Application Ref:	3/2021/0212	 Ribble Valley Borough Council www.ribblevalley.gov.uk
Date Inspected:	~	
Officer:	AB	
DELEGATED ITEM FILE REPORT:		REFUSED

Development Description:	Proposed alterations at the rear to create a new two storey extension and single storey extension including internal alterations.
Site Address/Location:	Cuttock Clough Farm Mill Lane Waddington BB7 3JJ

EXISTING AND PROPOSED
FLOOR PLANS

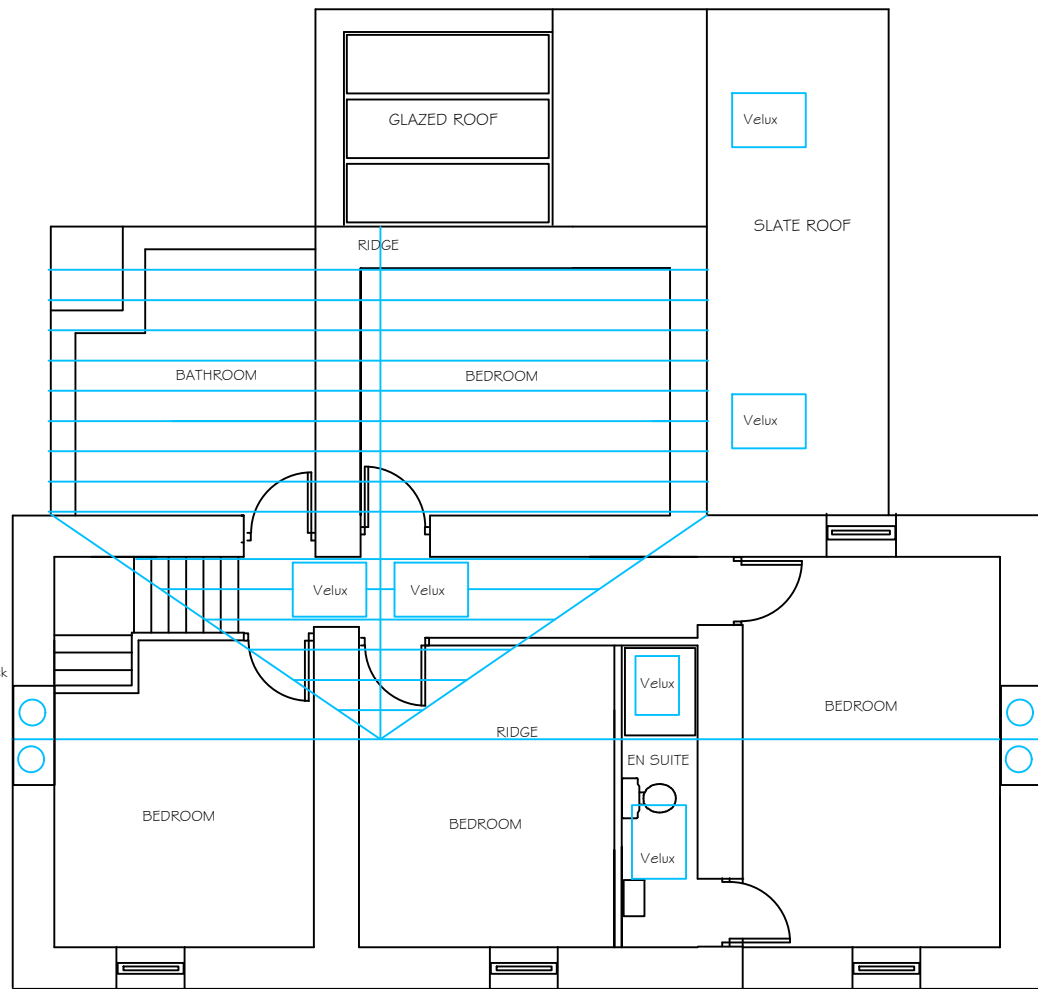
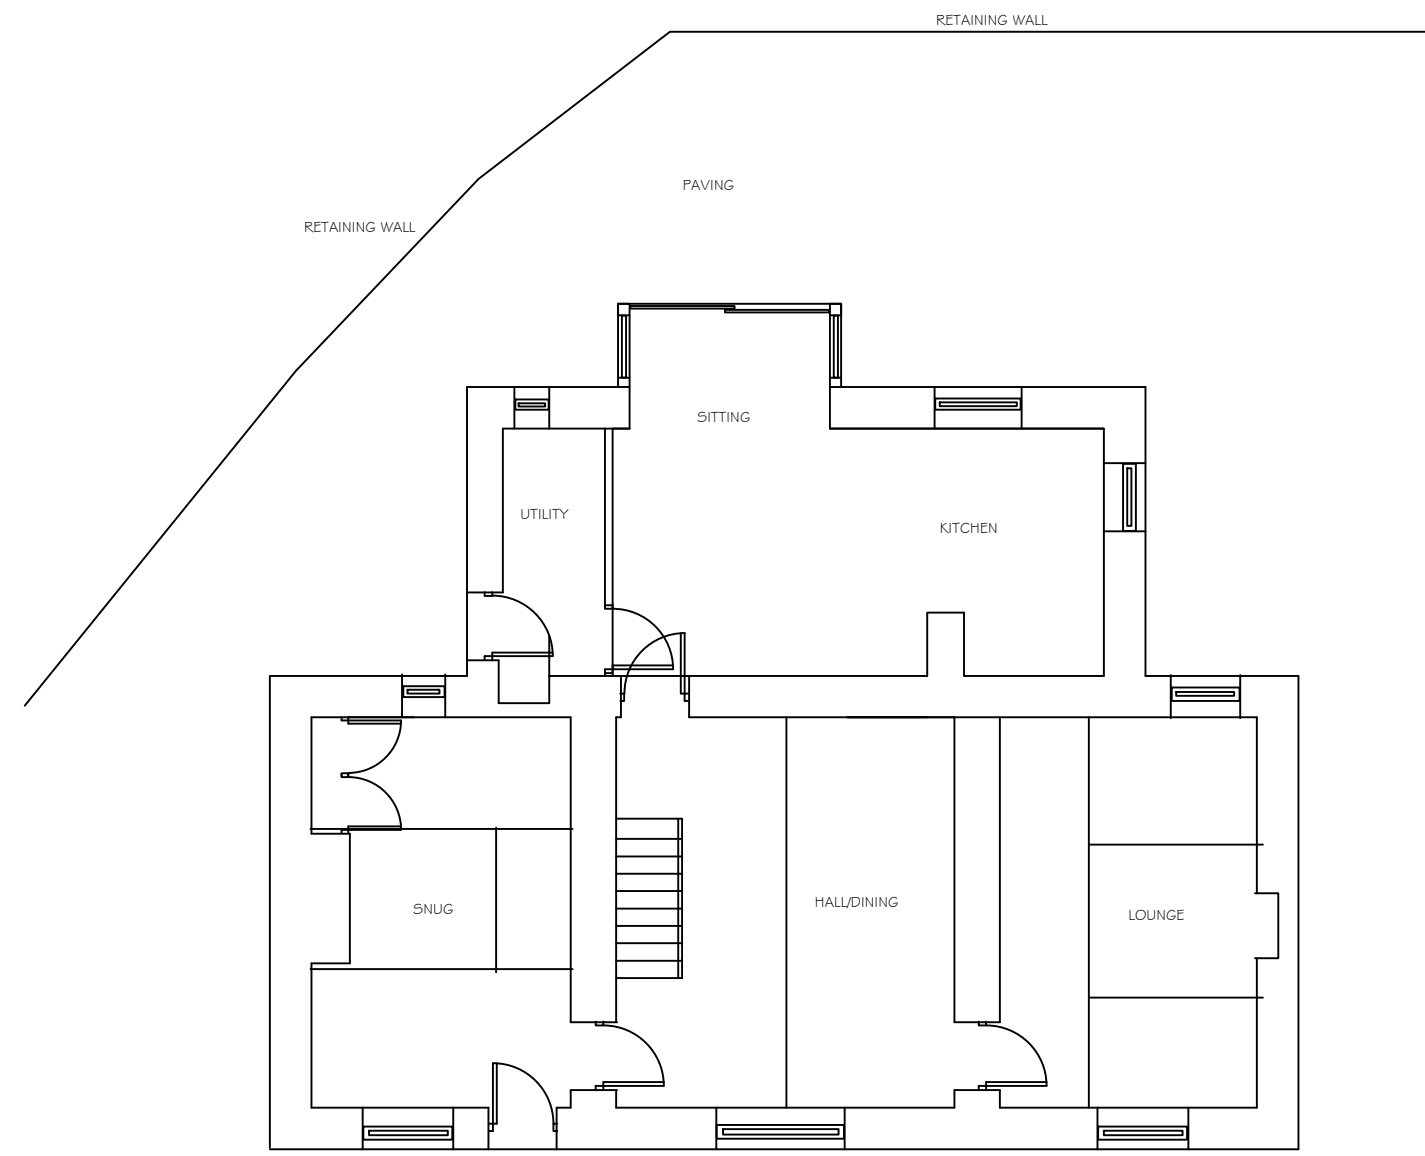
The proposed two storey rear gable would extend over more than half the width of the rear elevation of the original building. In terms of its proportions, it would be larger in width than the main property and would be experienced as a bulky and dominant addition to the main house.

The applicant has been given the opportunity to amend the scheme. Whilst some minor alterations have been made by setting the extension down at the eaves and ridge, this does not significantly reduce the overall bulk of the proposals that are still considered to be disproportionate.

Taking the above into account, the proposed development would result in a large and bulky extension that would constitute a disproportionate addition to the existing building. Accordingly, the application should be refused.

1. The proposed development, by reason of its size, scale and design, would result in a disproportionate and bulky addition to the existing farmhouse that would be harmful to the visual appearance and character of the building contrary to Policies DMH1 and DMH5 of the Core Strategy.
